**Consultation Response from KC,
Highways Development Management****2024/92553 Wappy Springs Inn, Lindley Moor Road, Lindley Moor, Huddersfield, HD3 3TD****Erection of mixed industrial development (Use Classes E(g)(ii, iii), B2 and B8); including demolition of existing structures, new yard, parking, landscaping, drainage features and ancillary structures.****Date Responded: 27/03/2025****Responding Officer: Ryan Kinder****Responding Ref: K2-13/7****Recommendation:** No objection subject to conditions.**Development Overview:**

- Transport Statement – ref 21025 Lindley Moor Rd TS dated 27/08/2024.
- Proposed site Plan – ref 2278 rev D dated 04/02/2025.
- stage 1 safety audit – ref 2025-01 Lindley Moor RSA1- Rev 0 dated 20 Jan 2025.
- stage 1 audit designers response – ref 2025-01 Lindley Moor RSA1- Rev 0 dated Jan 2025.

Drawing Title  
**PROPOSED SITE PLAN**

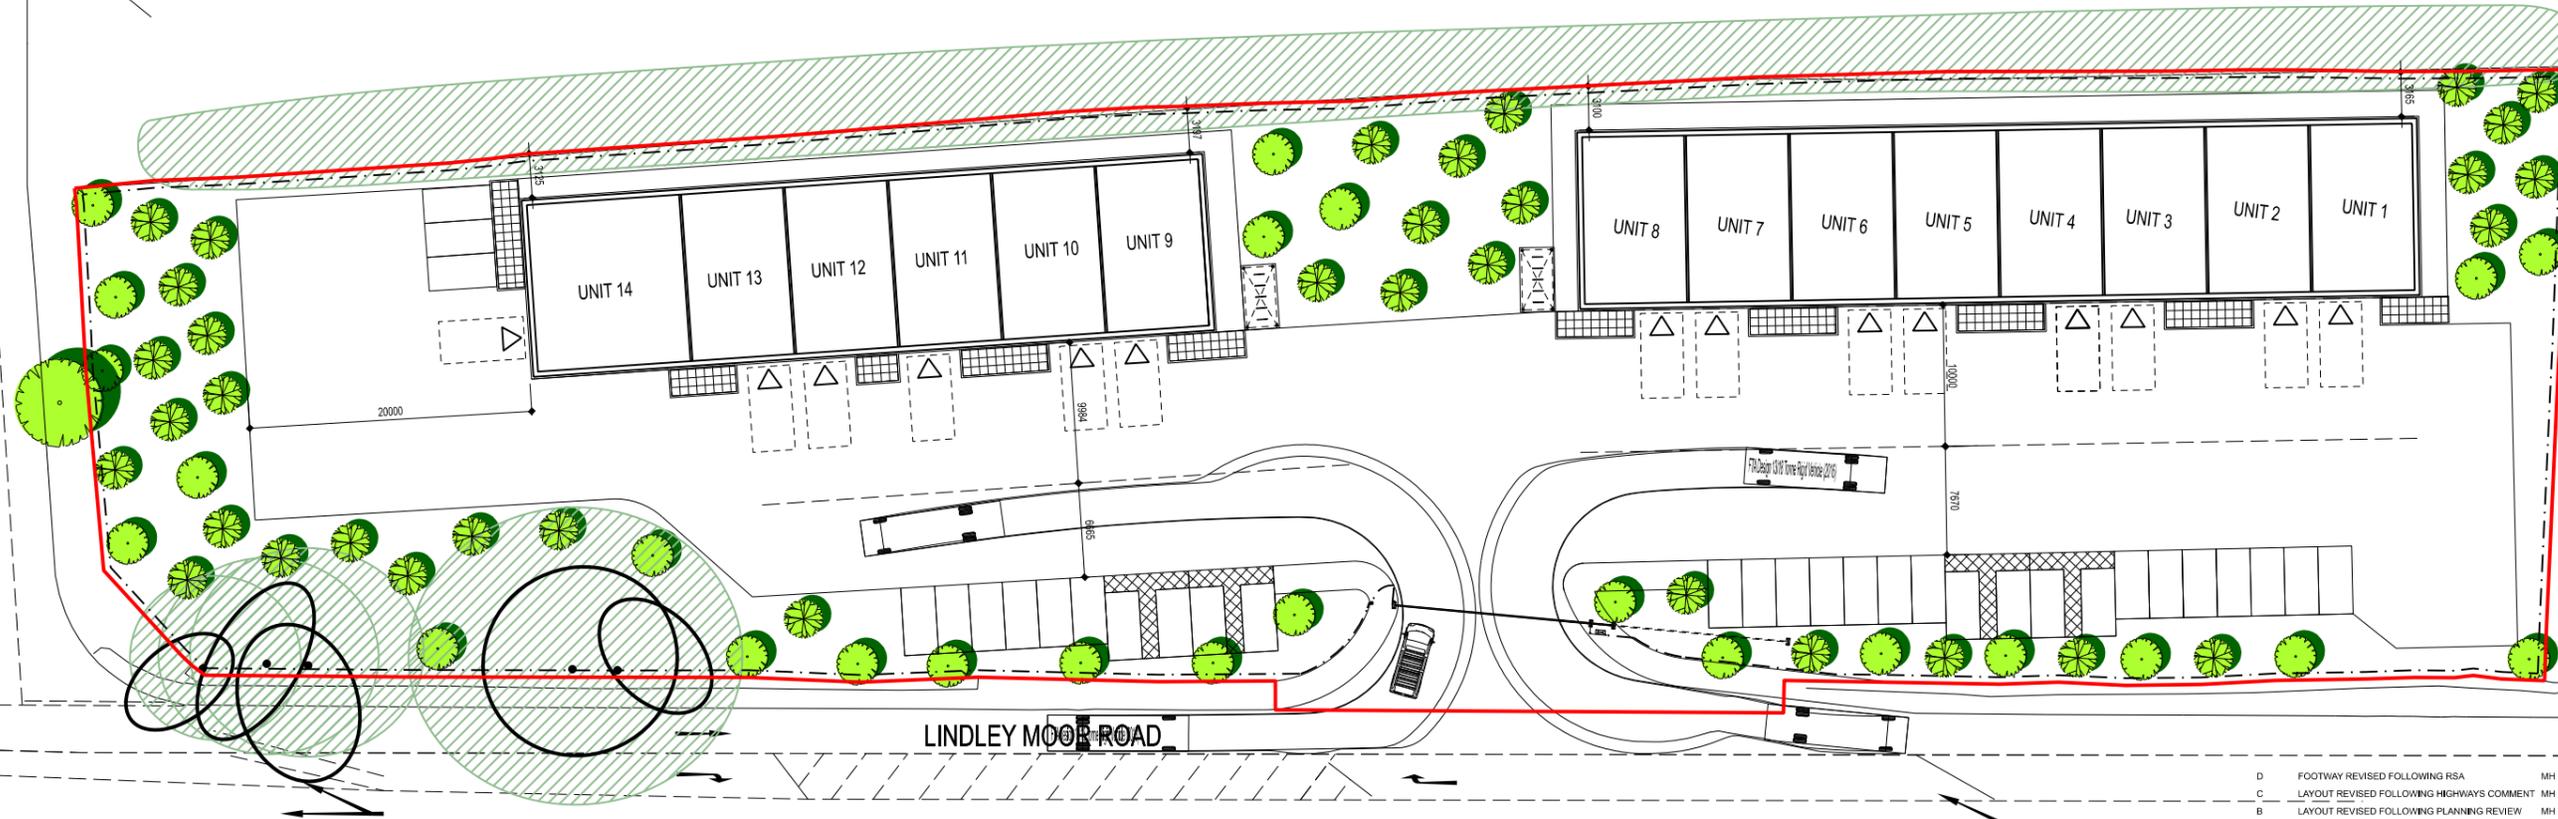
A revised site access has been provided which indicates access for HGV vehicles can enter the site unhindered and be free from conflict with vehicles making turning manoeuvres internally. It should be noted that further information/changes may be required at detailed design stage should be these be required by the Councils section 278 team. A suitable condition to this effect will be suggested accordingly.

A stage 1 safety audit and designers response has been carried out in accordance with GG119 and considered acceptable.

There is no splay to prevent trailer overrun of the footway by longer vehicles turning left out, the alternative being them swinging out and overrunning the oncoming central right turn lane, which would be unsafe. To summarise it is therefore recommended that the site be reconfigured with the units fronting Lindley Moor Road, with parking and access road to the rear.

The proposed parking provision needs to be carefully considered with the correct provision and sizing

of parking bays, enough disabled provision swept paths of vehicles manoeuvring in and out of bays where space appears tight in some instances.

Notwithstanding the details shown on the approved plan 2102511 dated Nov 24, prior to the development being brought into use, a detailed scheme for the provision of a right turn lane from A642 Lindley Moor Road into the site with associated signing and white lining shall be submitted to and approved in writing by the LPA. The scheme shall include construction specifications, white lining, signing, surface finishes together with an independent Safety Audit covering all aspects of the work. Unless otherwise agreed in writing by the LPA, all of the agreed works shall be implemented before any part of the development is first brought into use.
